RE: BL-25-00003

KCPHD has reviewed the application for BL-25-0003 and has one comment.

GRAAFF PROPERTY

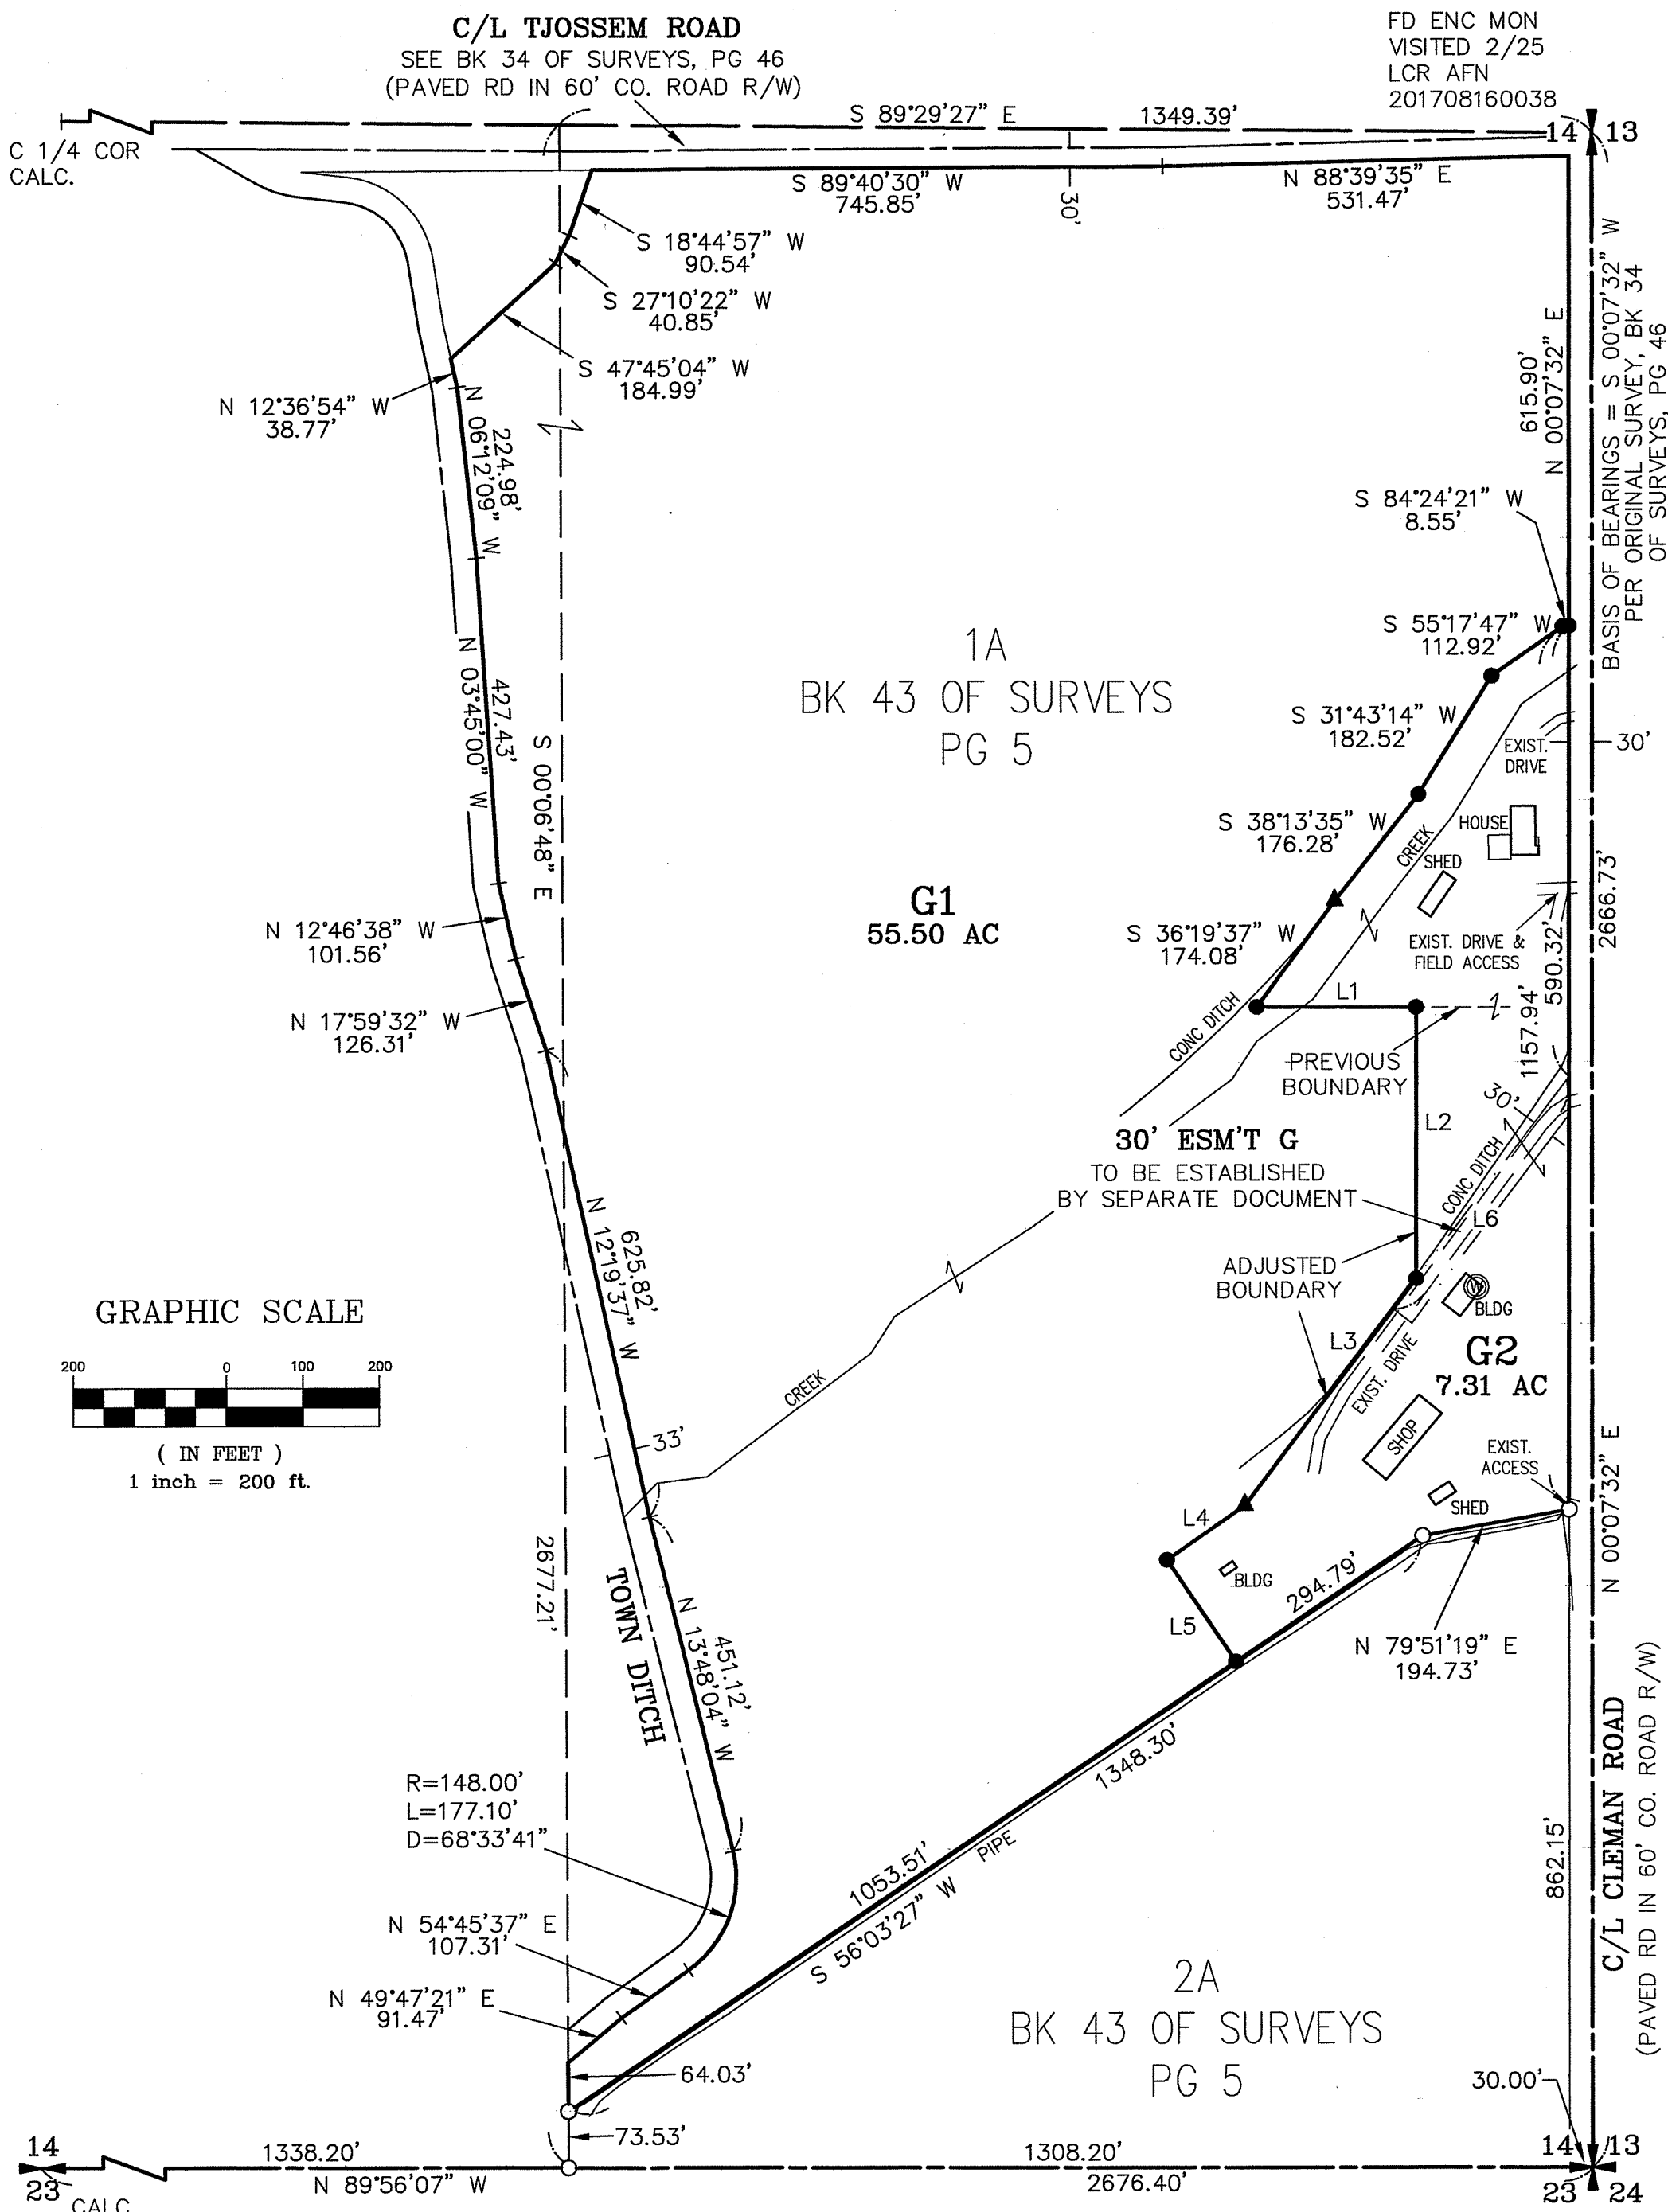
1. Maintain the appropriate set backs from property lines for any wells and septic systems.
